# HAY CREEK VALLEY

# FINAL GRADING & EROSION CONTROL PLANS

## DECEMBER 2023

PCD FILE #: SF2324

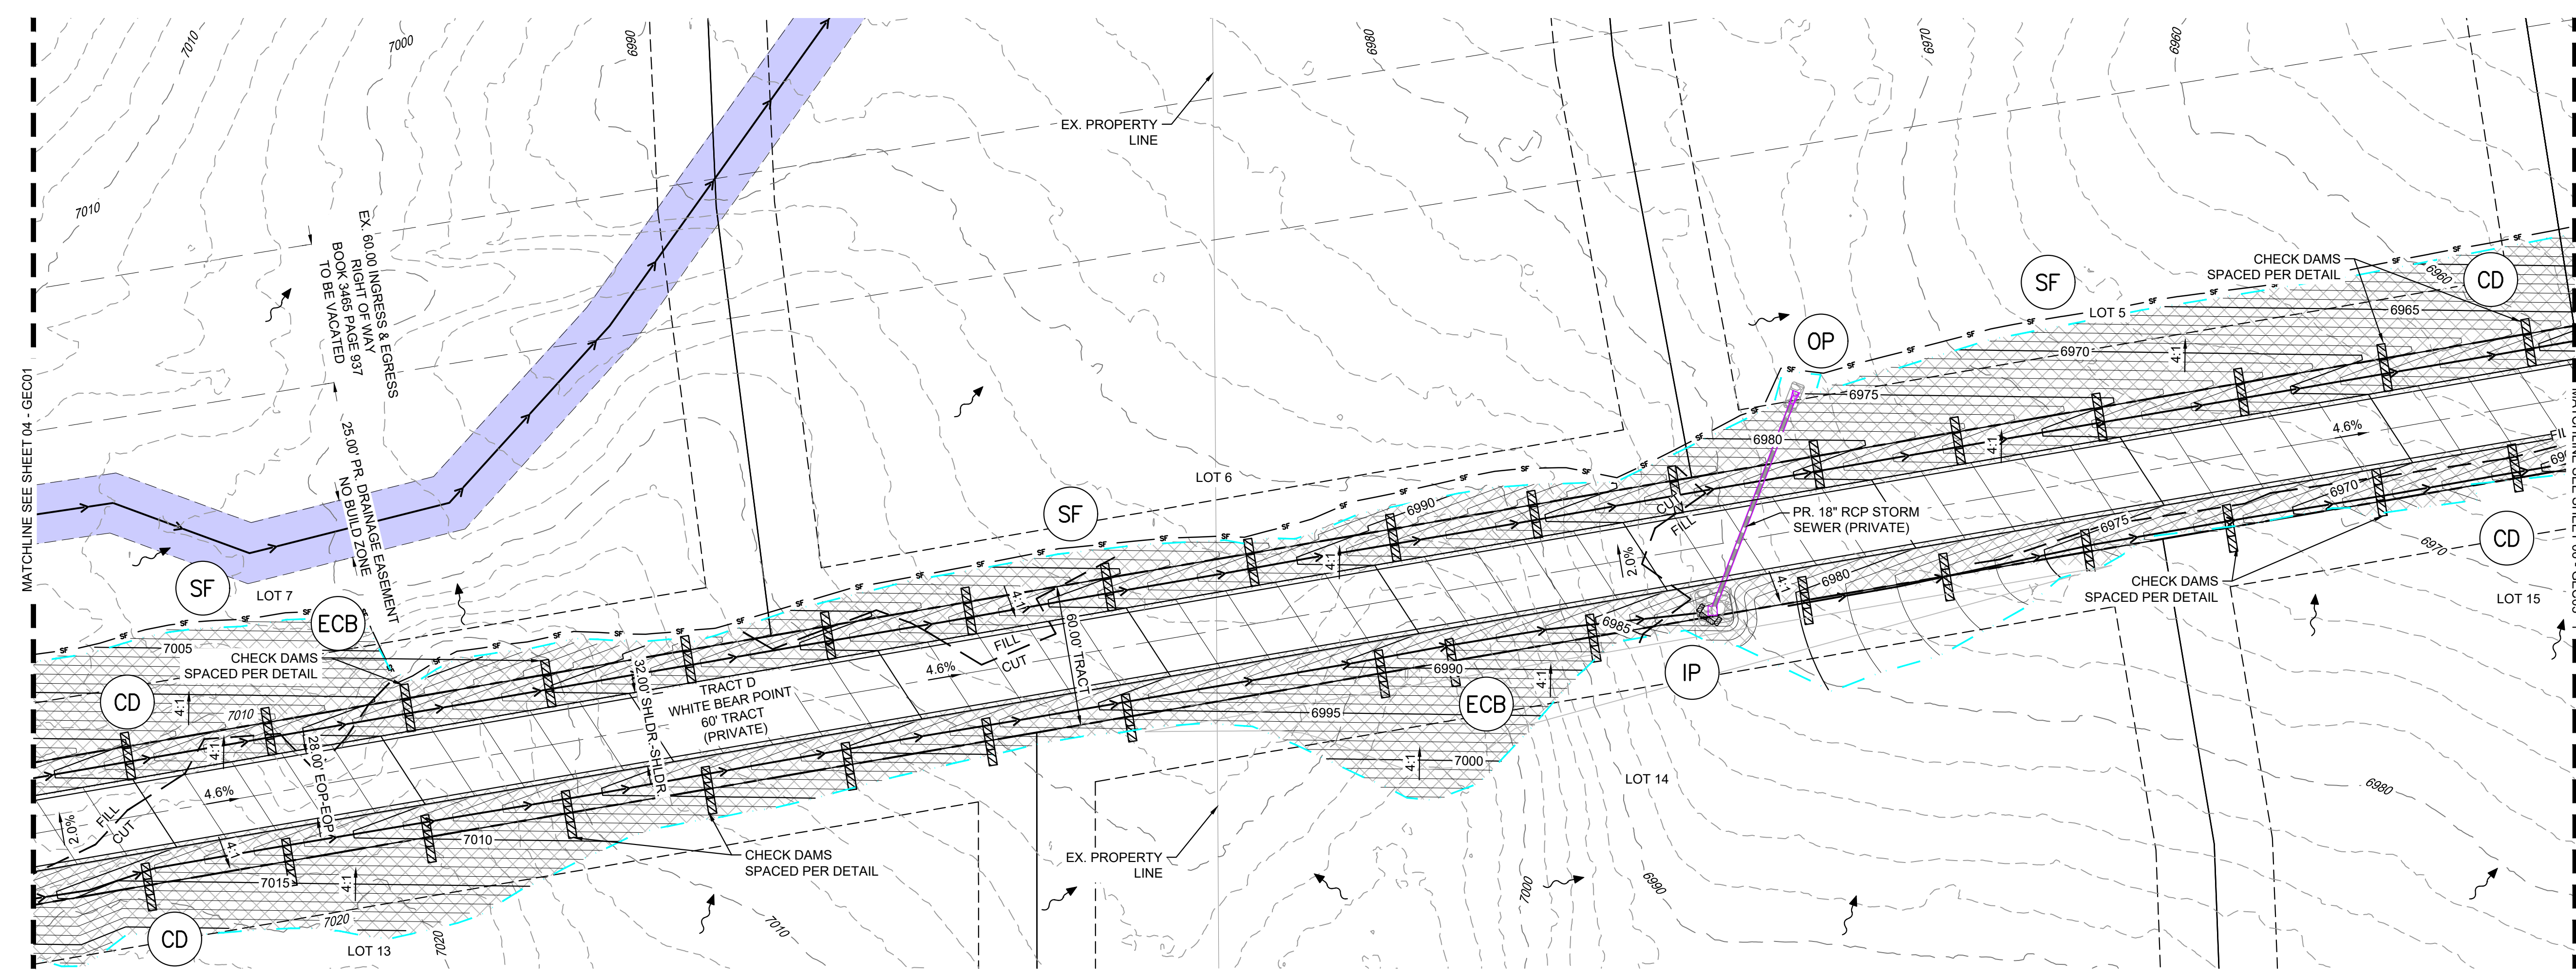
Why no PS/MU in roadside areas in addition to the ECB which is shown?

PS ADDED TO ALL AREAS WHERE ECB IS BEING PLACED, MU NOT NEEDED
